Statement of Deficiencies and Plan of Corrections

Facility Name: KIDDIE GARDEN, LLC
Location: 237 SPRING ST
PORTLAND, ME 04102-3712

Date of Inspection: 6/17/2015
Inspector: MICHAEL J. MINKOWSKI
Date Sent: 6/23/2015

Rough
Sketch of Store Front 237 Spring St.
not to scale

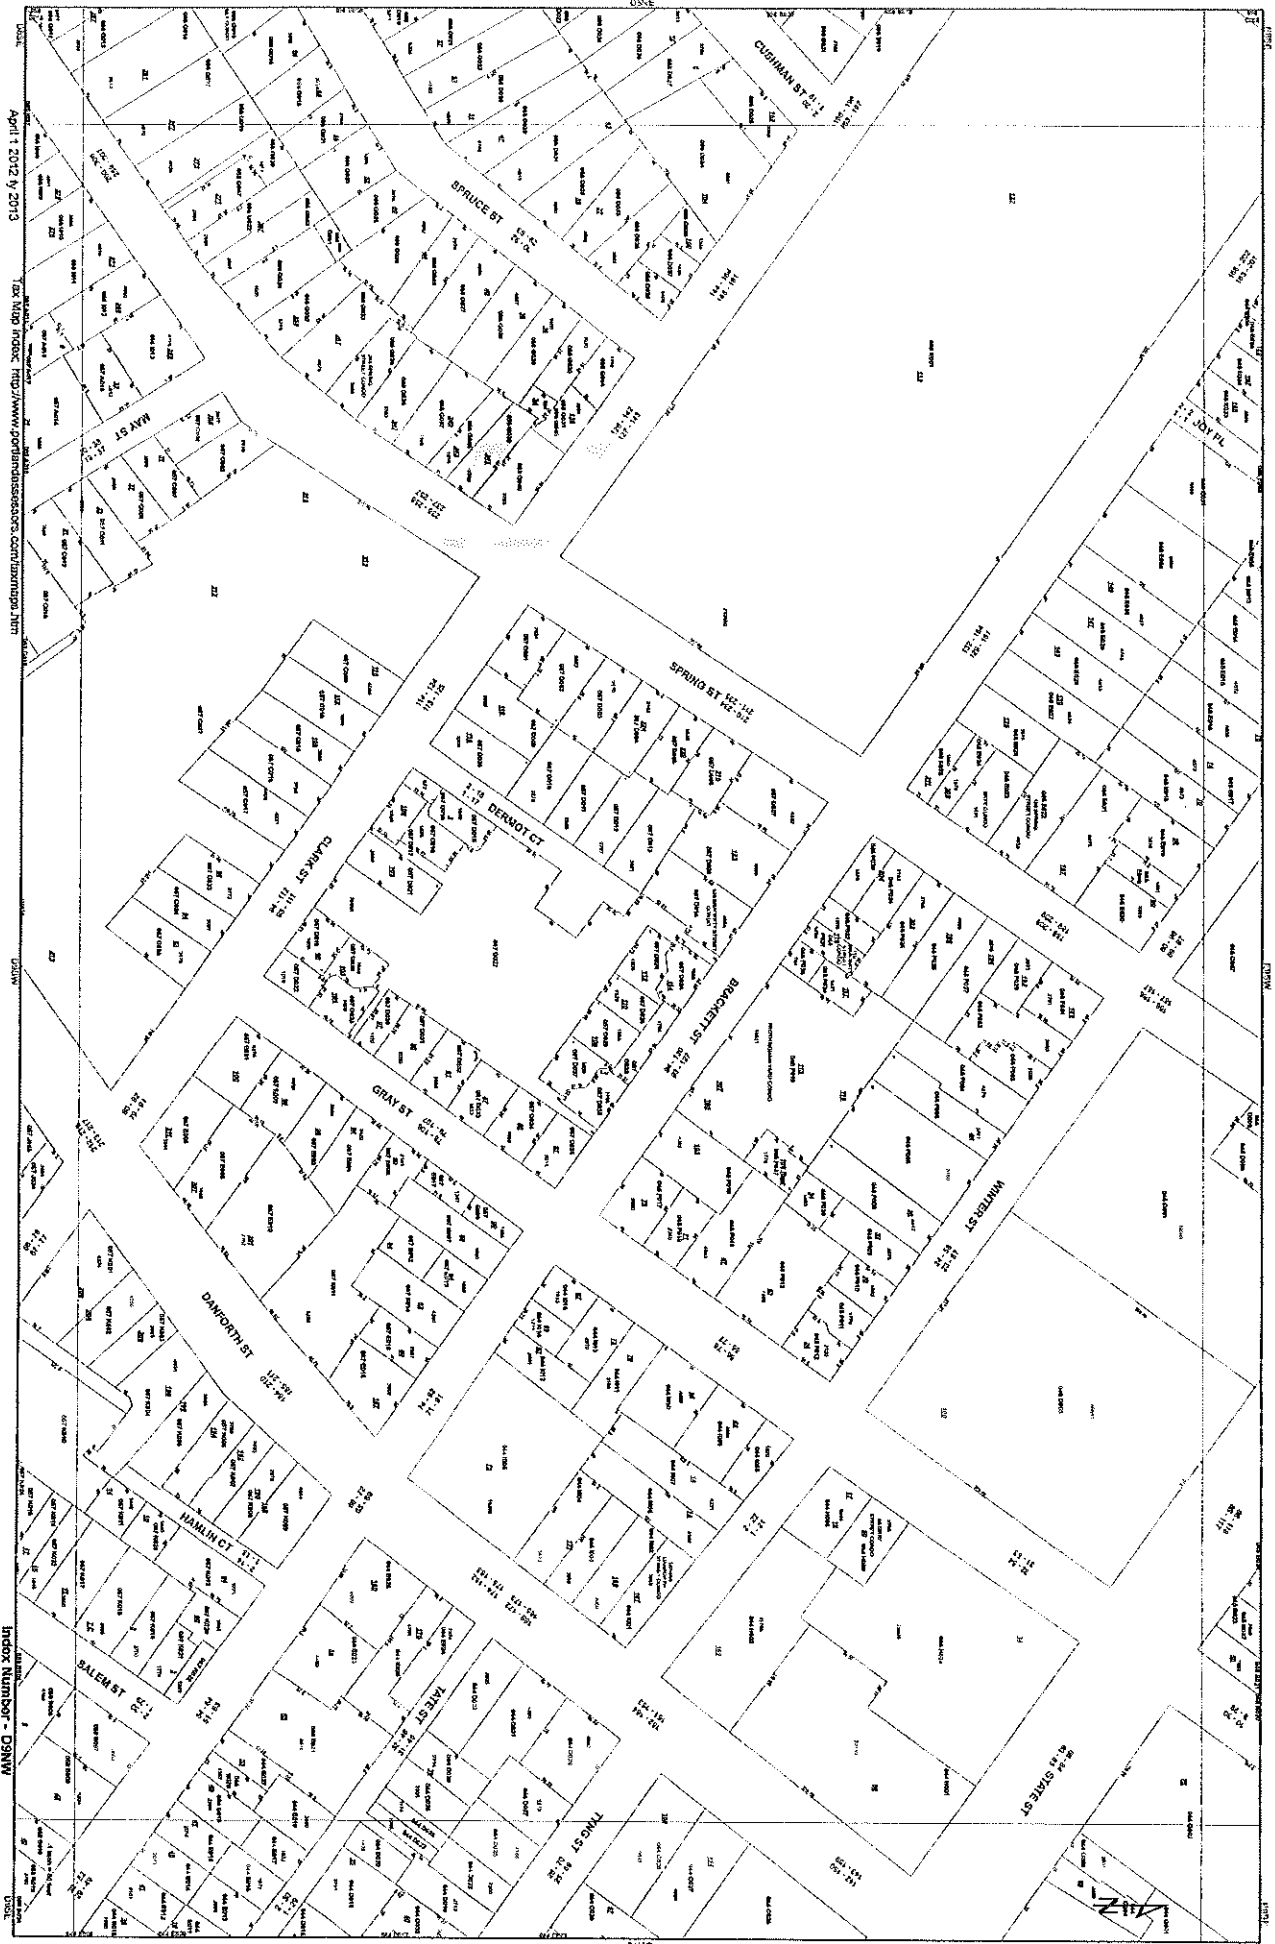
| 1. VIOLATION | Violations found as described Daycare Room requires a second means of escape, either a door or complaint Egress Window remotely located from main entrance. REFER ENCLOSED WINDOW SPEC SHEET | |
| 3. VIOLATION | Violations found as described Stair to kitchen does not meet minimum riser/run requirements. (4 max riser 7"/minimum 4") REFER ENCLOSED STAIR SPEC SHEET. | |
